Phone: 0300 123 6780
Email: Kathryn.Walsh@lancashire.gov.uk
Your ref: 3/2024/0615
Our ref: 3/2024/0615/HDC/KW
Date: 05 December 2024

Location: Land at Pendleton Road Wiswell BB7 9BZ
Proposal: Proposed change of use from agricultural building to single residential dwelling and associated residential curtilage together with hardstanding/parking area (part retrospective)
Grid Ref: 374819 437692

Drawing No. SC / 23 / 200 - 001	Rev	
Scale 1:100 @ A3	Date - Feb 2024	Planning
Created By A Mc	Check By	Building Control
		Client
		Sketch
		Information

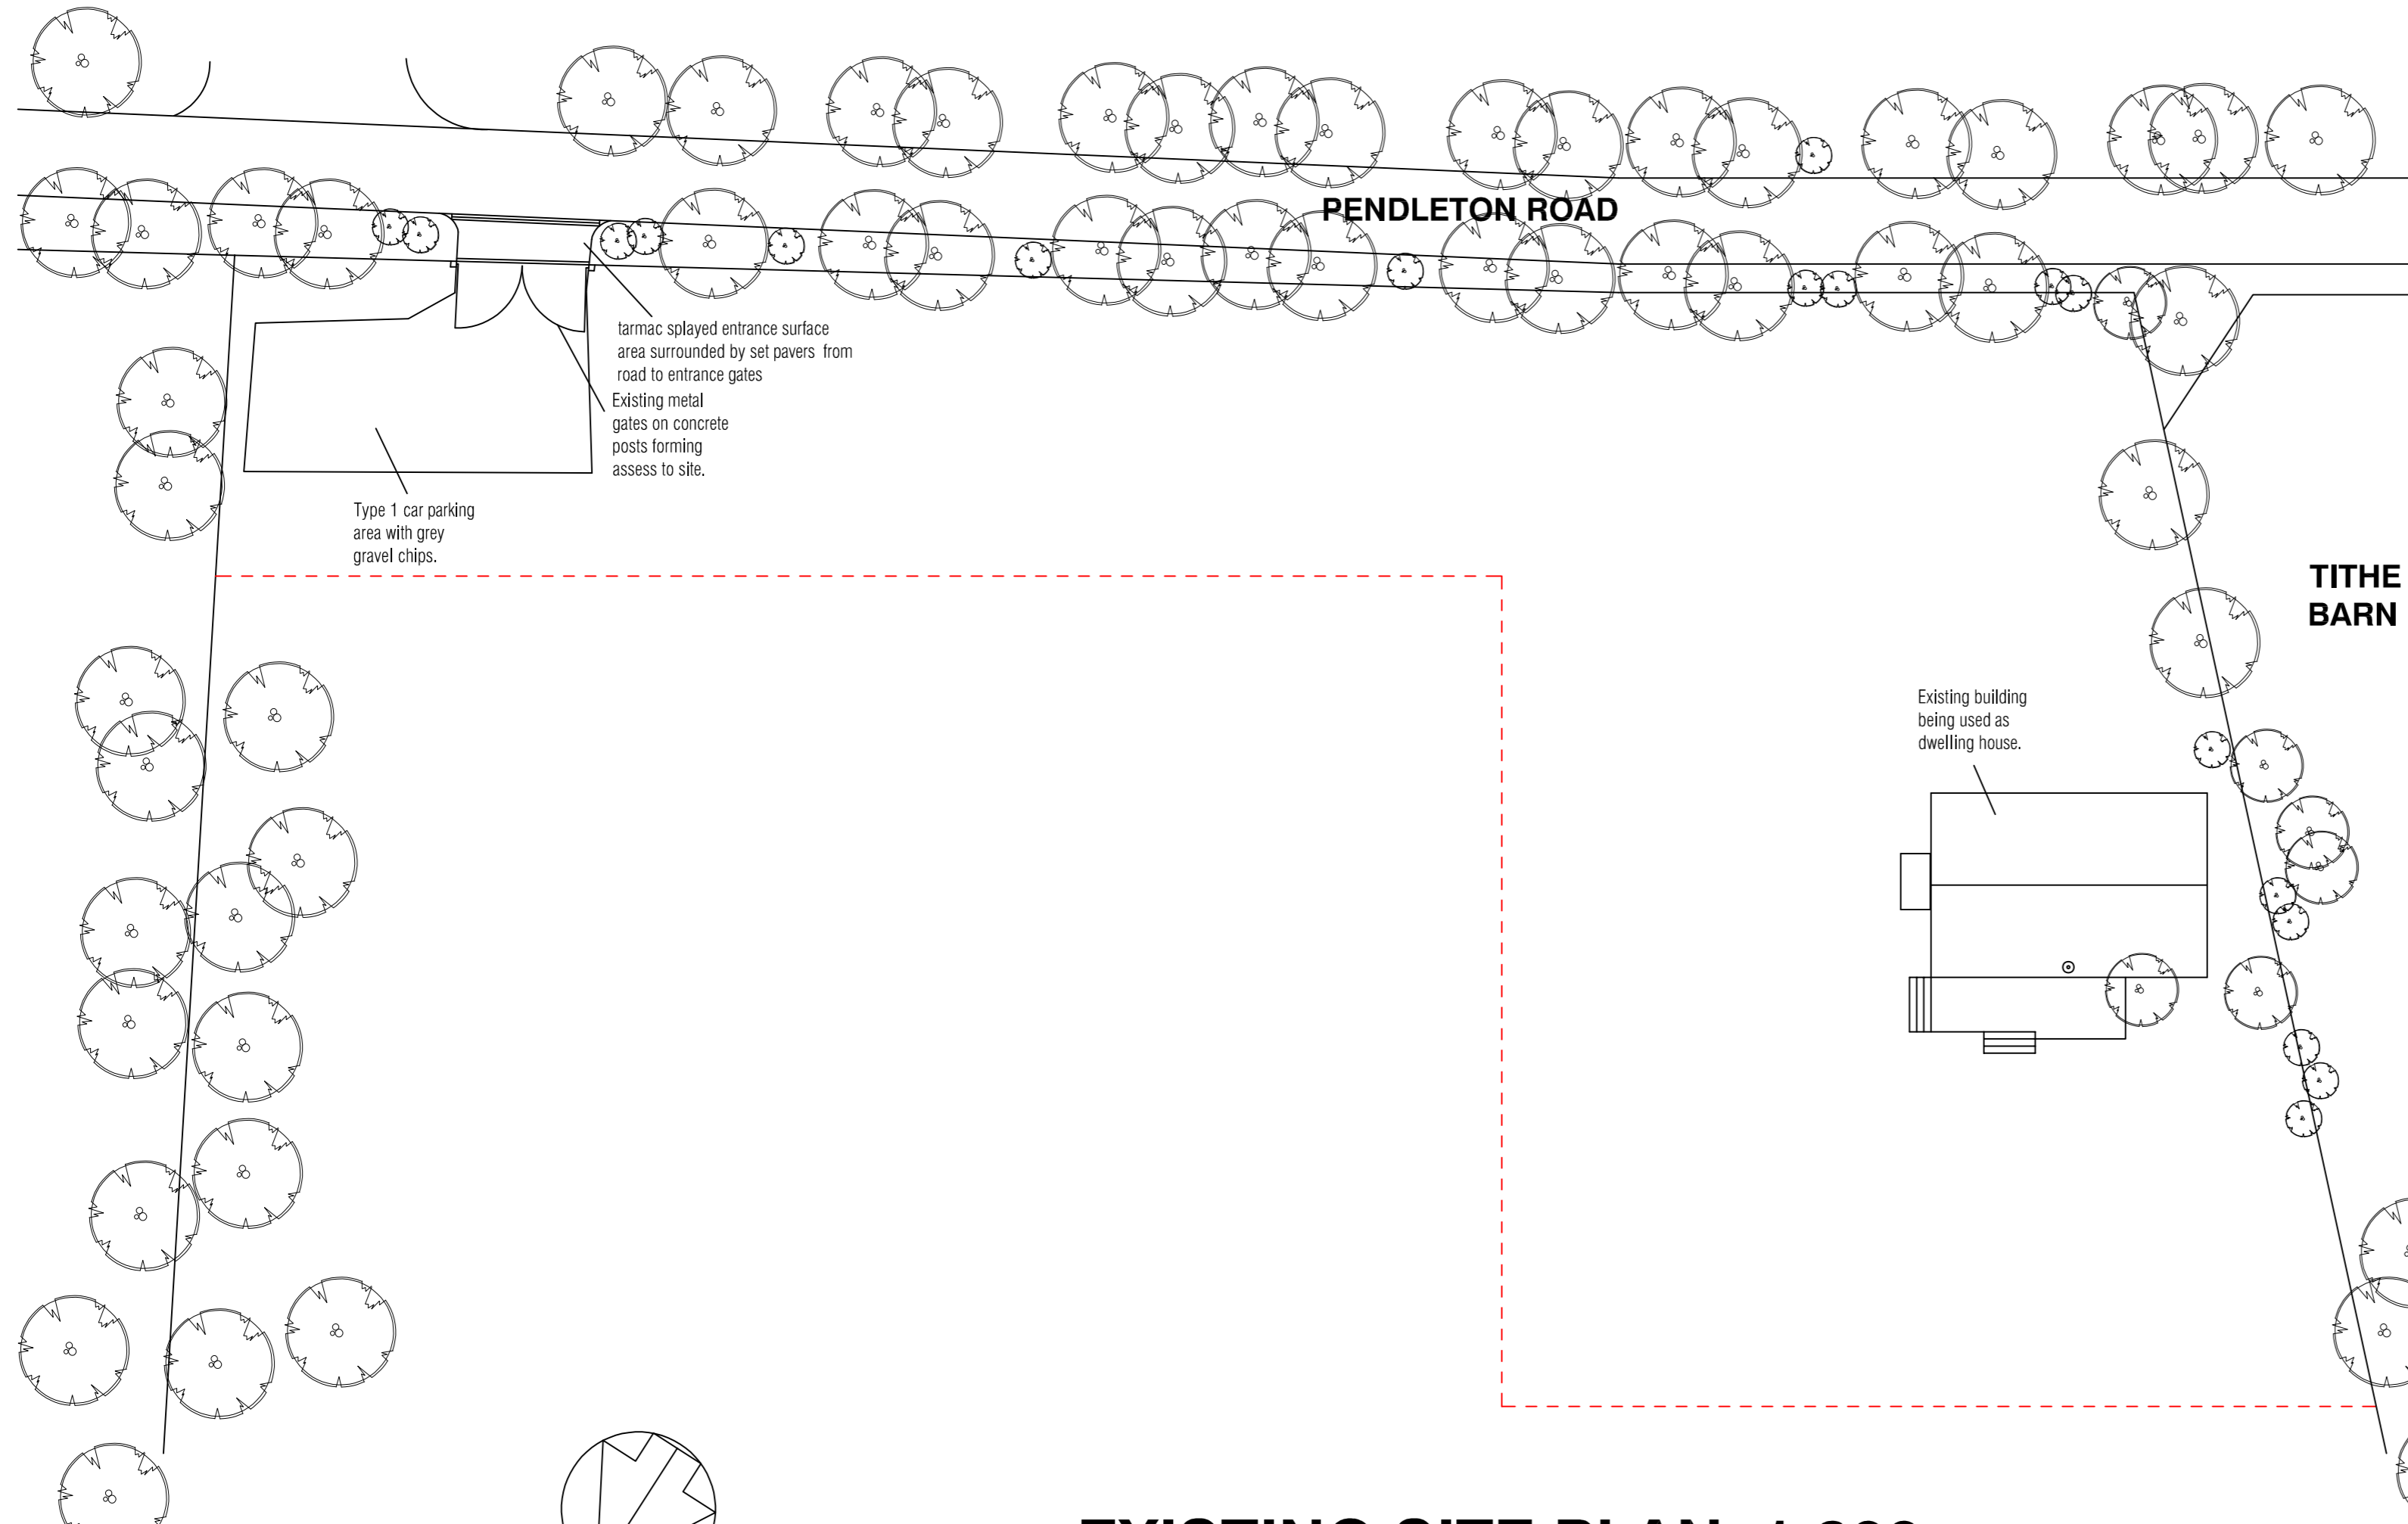
The LHA has reviewed drawing number SC/23/200 - 001 titled existing site plan and note that the car parking area is approximately 11m by 5m. Given the single-track nature of Pendleton Road, it would be beneficial to provide turning within to allow ingress and egress in forward gear.

The site shall increase its sustainable transport options to encourage and promote sustainable transport use. Therefore, the development shall include covered secure cycle storage to ensure the provision and availability of adequate cycle parking and the promotion of sustainable forms of transport. Additionally, due to the nature of the application, it is expected that a charging point for electric vehicles is included in the development.

Drawing No. SC / 23 / 200 - 002	Rev		
Scale 1:100 @ A3	Date - Feb 2024	Planning	
	Created By A Mc	Building Control	
	Check By	Client	
		Sketch	
		Information

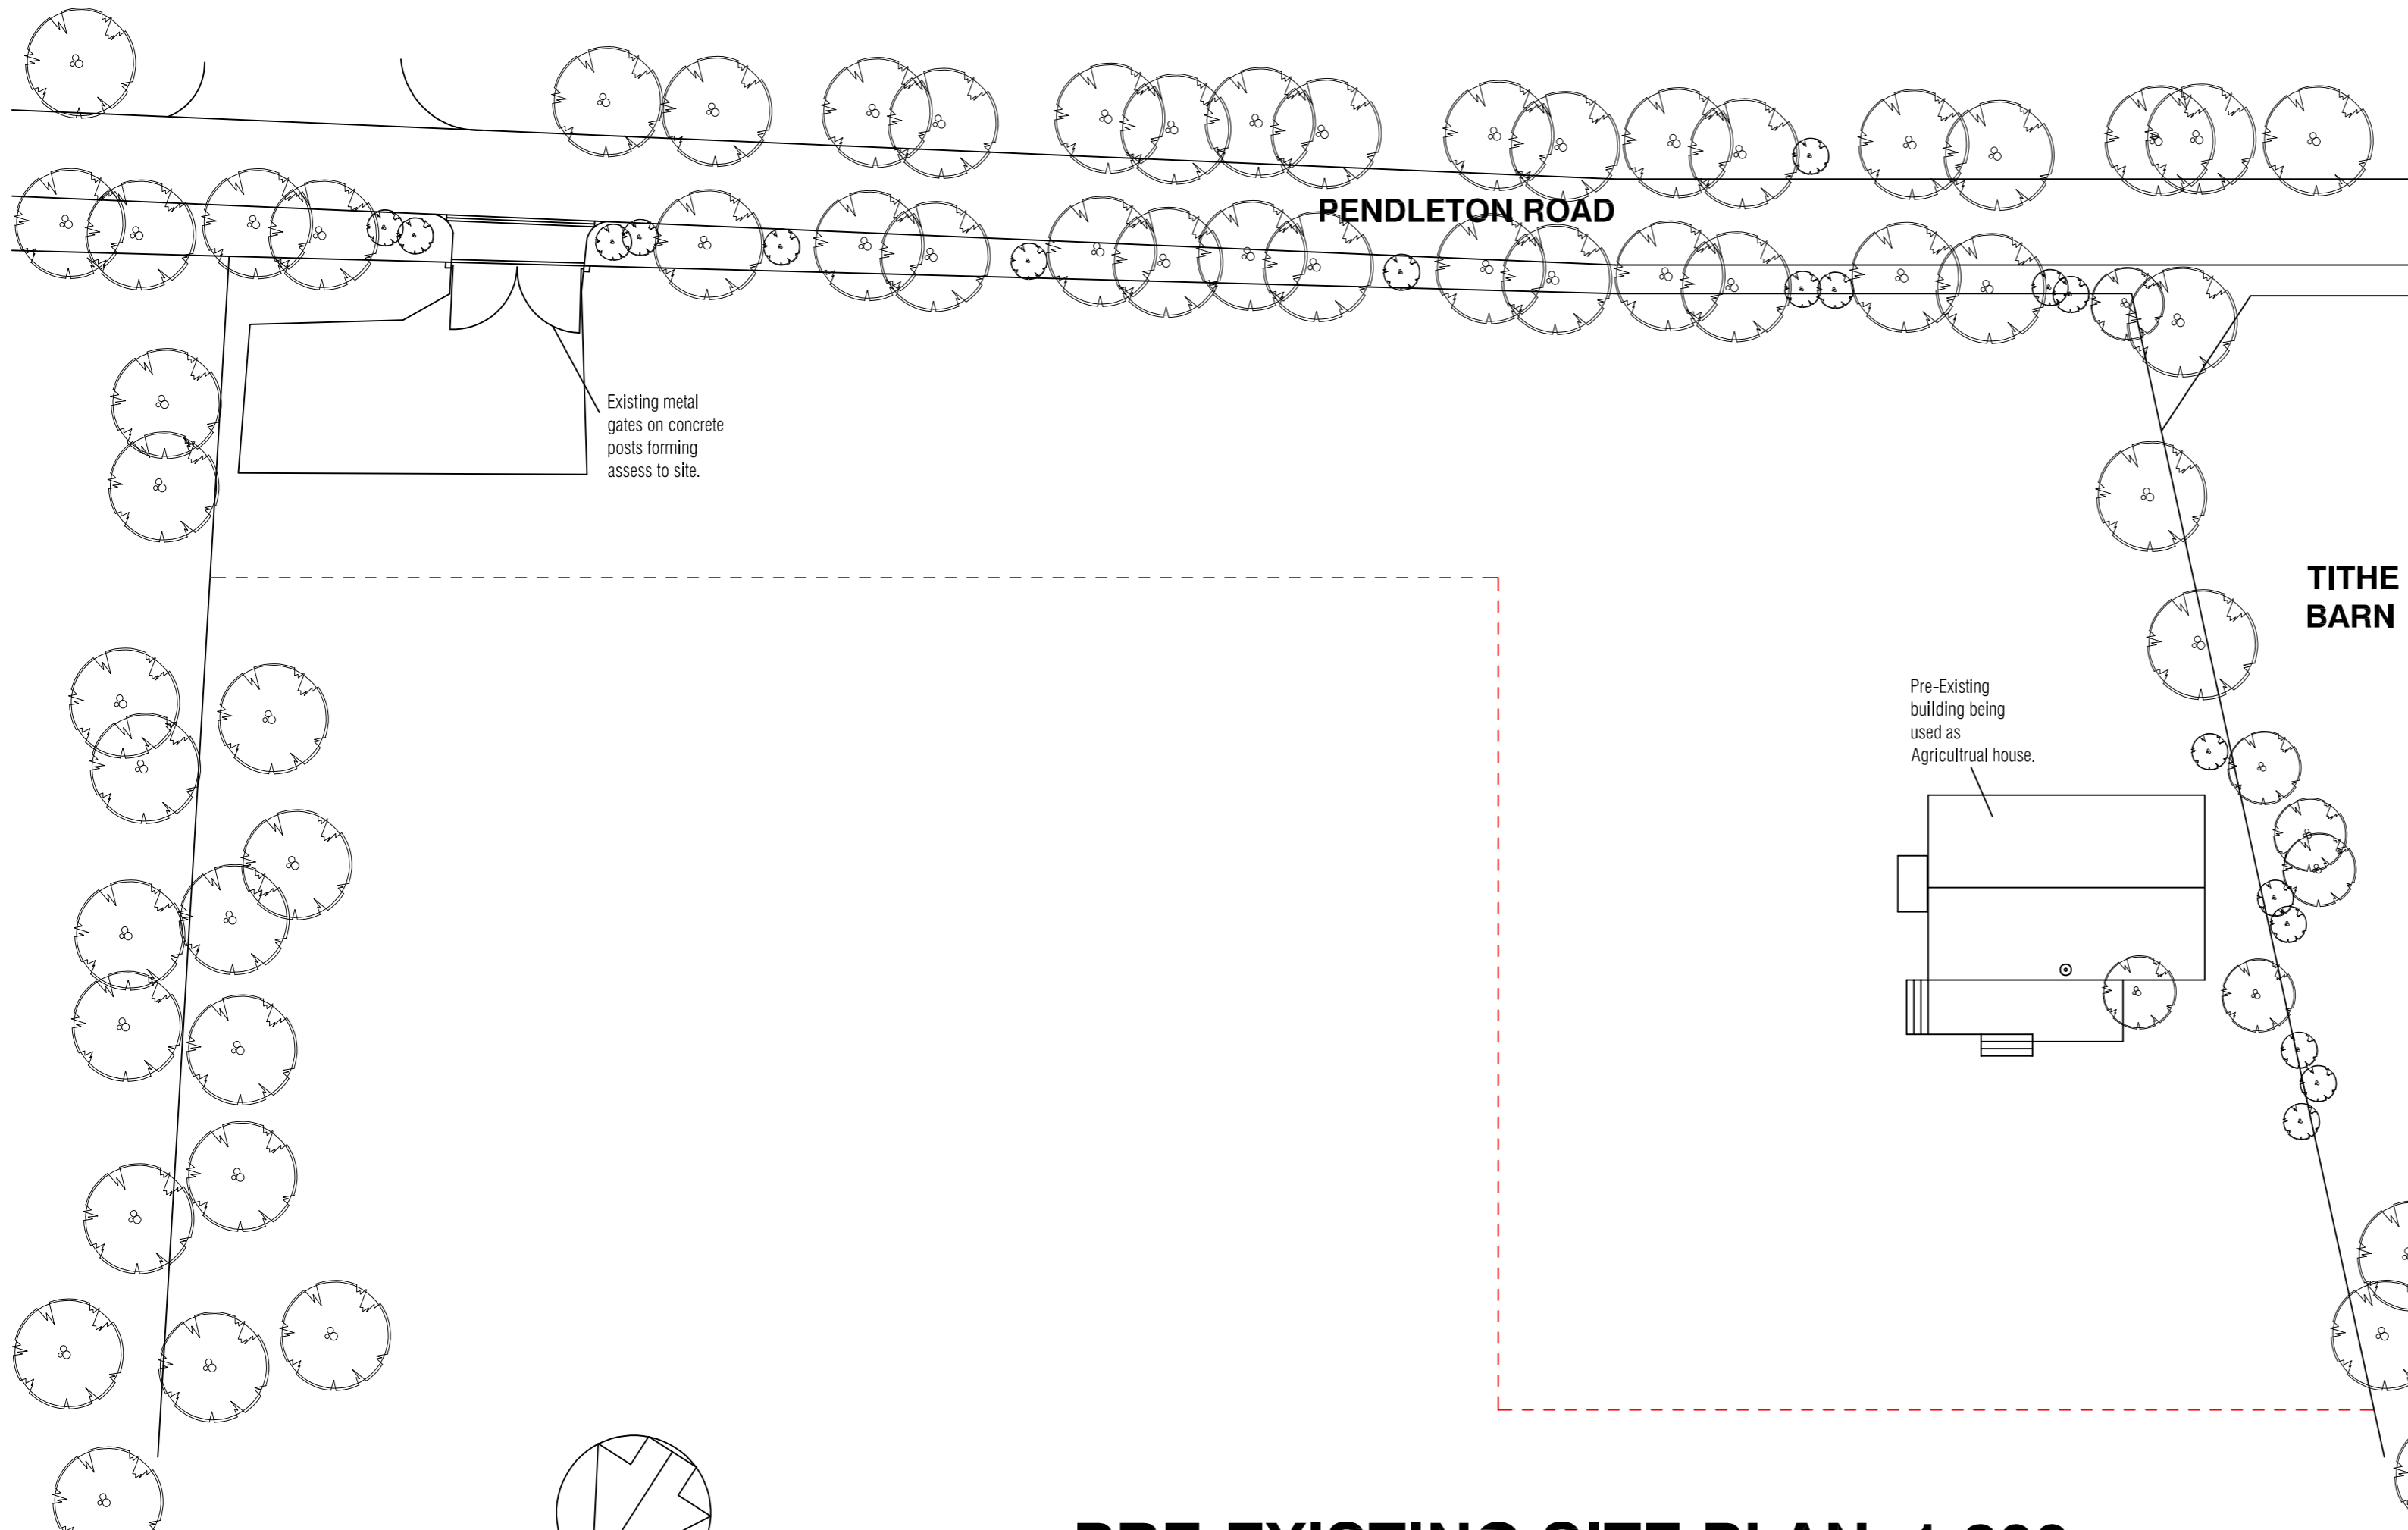
The LHA have reviewed drawing SC/23/200 – 002 and note that the site is being accessed from Pendleton Road. Pendleton Road is unclassified and is subject to a 30mph speed limit.

The access appears to have originally been a field gate which has since been hard surfaced. Given the appearance of the vehicle crossing, it would appear that this has been constructed within the adopted highway without permission from Lancashire County Council. Therefore, the applicant may be required to enter into an appropriate agreement with the LHA for the vehicle crossing to be inspected and any necessary remedial works to take place.

It is also expected that the first 5m into the site be properly consolidated and surfaced in bound porous materials (not loose stone, gravel or grasscrete) to prevent debris from being dragged onto the highway. Any gates erected at the access should be positioned 5m behind the carriageway edge to accommodate a vehicle within the access before operating the gates.

To ensure adequate intervisibility between highway users at a new access a visibility splay set 2 metres back from the near edge of the carriageway and extending 43 metres in both directions should be provided. (The site line requirement is based on table 7.1 from Manual for Streets).

The visibility splay should be wholly within the land which the applicant controls and/or the adopted highway and nothing shall be erected, retained, planted and / or allowed to grow at or above a height of 0.9 metres above the nearside carriageway level which would obstruct the visibility splay of the proposed access.

The applicant should provide accurate details of the required sight line requirement, before determining the application.
